From: Liz Annalls [REDACTED]
Sent: 09 November 2020 09:36
To: Michael Eastham <Michael.Eastham@arun.gov.uk>
Subject: RE: *EXTERNAL: FW: A/155/20/DOC - Ecology

Please see the following email from the applicant regarding the area of scrub at the northern end of the site on Land South of Water Lane, Angmering.

Are you satisfied that discharge of condition application **A/155/20/DOC** can now be approved?

I have received the following consultation response from the Ecological Advisor to **Condition 10** in discharge of condition application **A/155/20/DOC** relating to Land South of Water Lane, Angmering.

Figure 3: Phase 1 Habitat Map

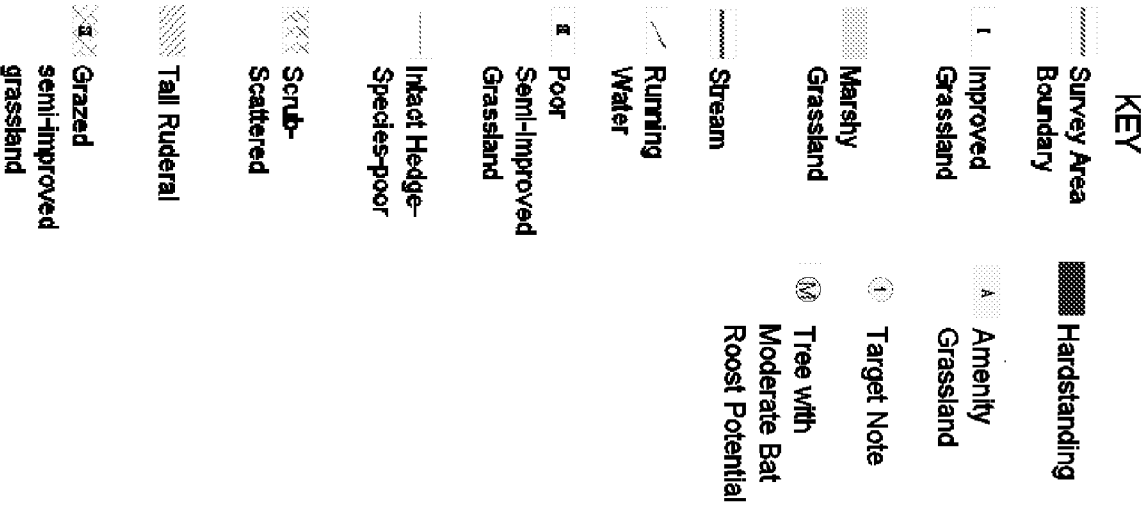
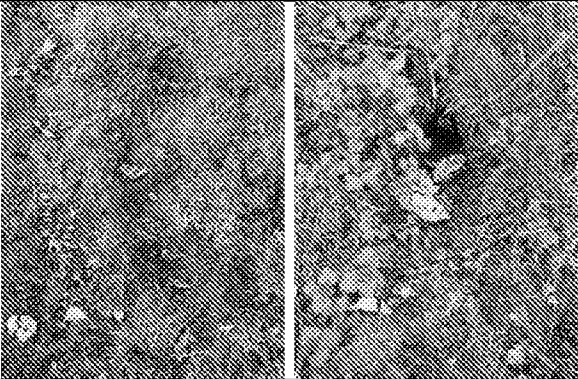
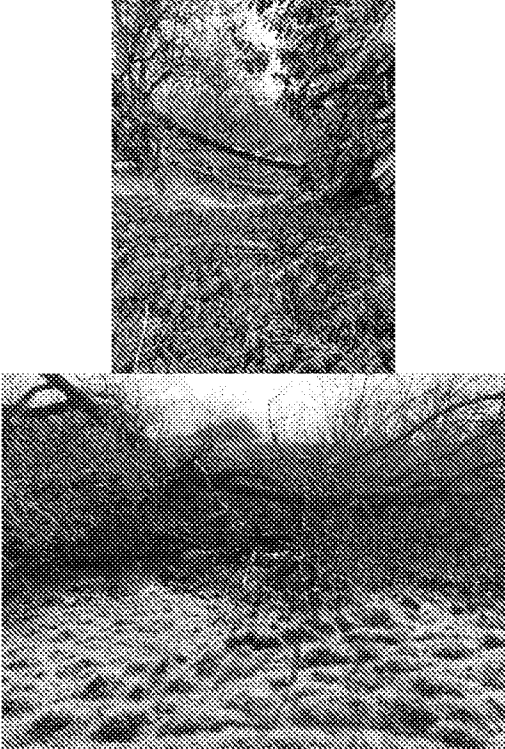
As clearance will be taking place for access within this area, and the surveys which were done are over 3 years old (May 2017) I am not happy that dormice are not now using the site. Please can there ecologist do a update for this to confirm if there has been any habitat changes / change in potential for dormice.

Can the applicant please also confirm that there will be no loss of scrub vegetation to the north of the site (excluding the hedgerow along the A2820). If any works to this scrub is required further survey work for dormice will be required.

It has been confirmed that the scrub area to the north will be retained in its entirety (no loss of scrub) excluding that required for access. We have been informed by our ecologist, that the section to be used for access isn't suitable for dormouse and this is mentioned within the Preliminary Ecological Appraisal (dated May 2017).
